Your Ref: OWPC5845
Our Ref: R/97/15/HH 16-04-2015
Please ask for:
Mr D Easton

Single storey side extension to create kitchen/family room & additional bedroom. Porch extension to front of property
14 Hawke Close Rustington

Proposed Roof Plan (1:100)

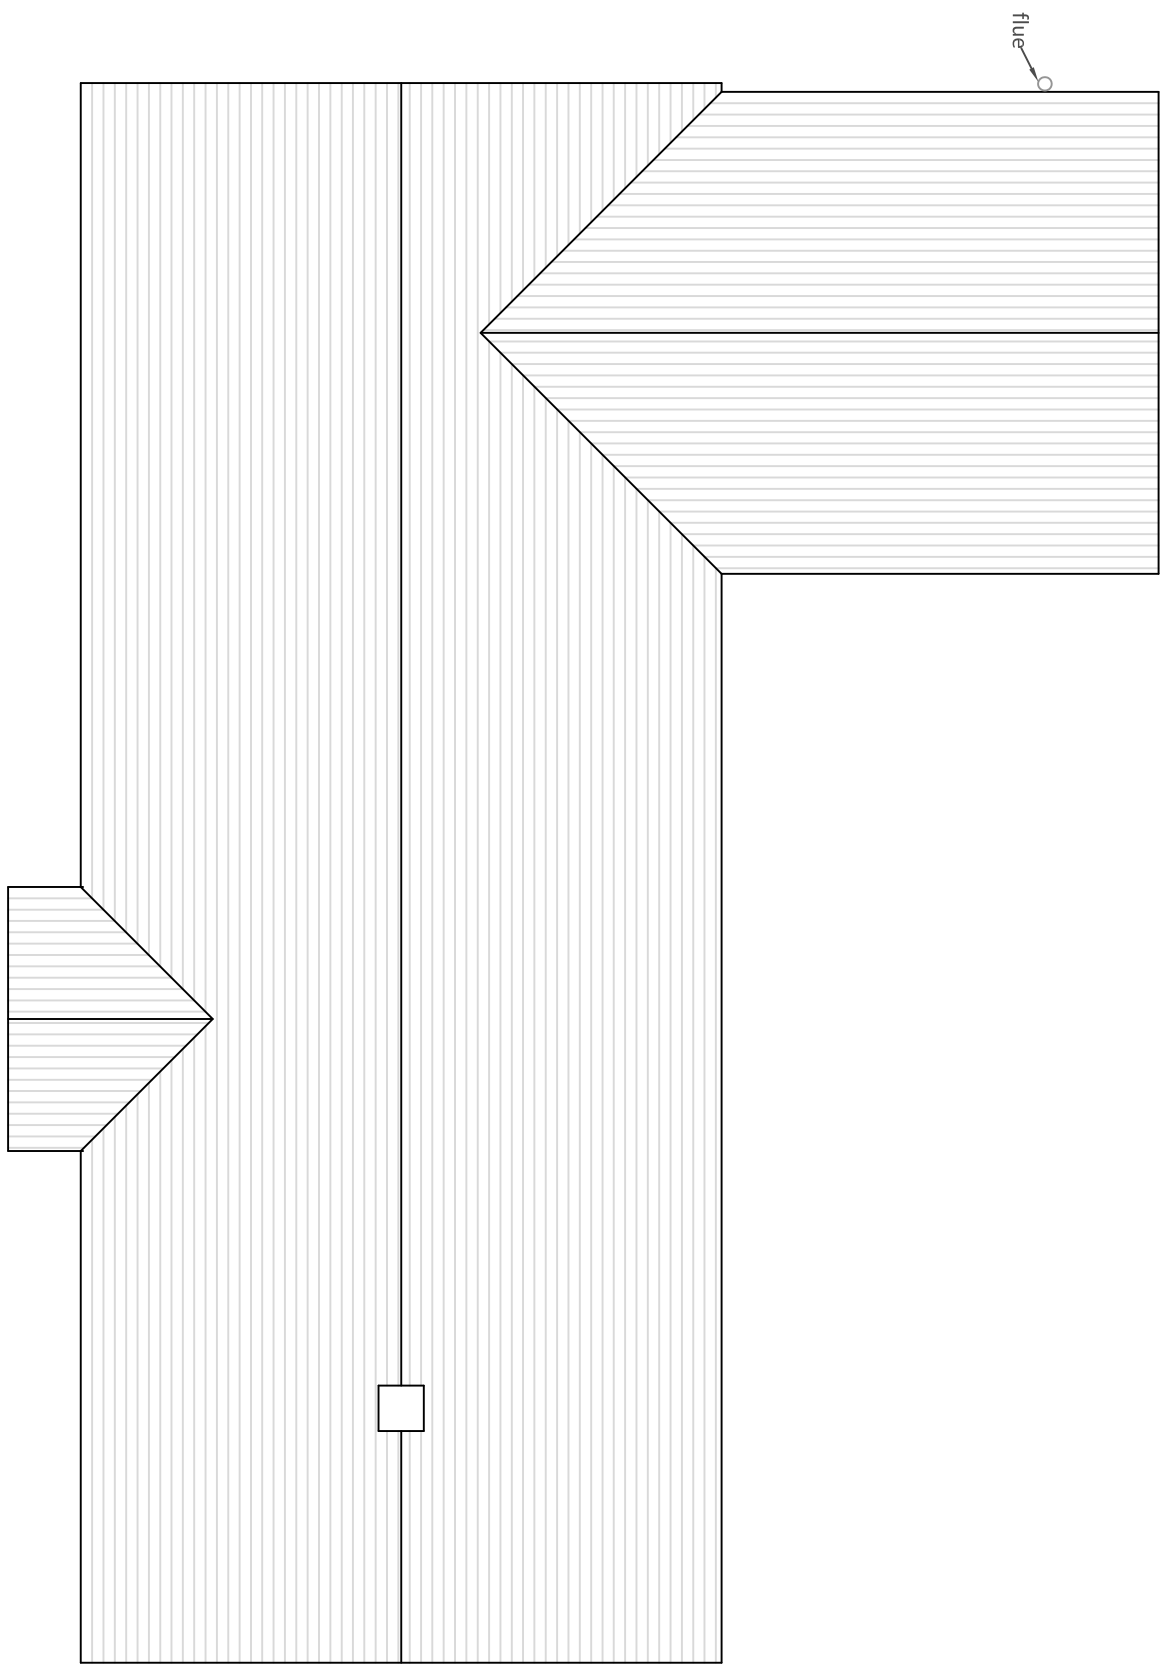
We note that the proposed extension is approx five metres closer to our property and at its closest point to us includes a wood burning stove. As we are downwind of the south west prevailing wind, we object to the noxious fumes exiting this flue we will experience and potentially polluting our home and garden.
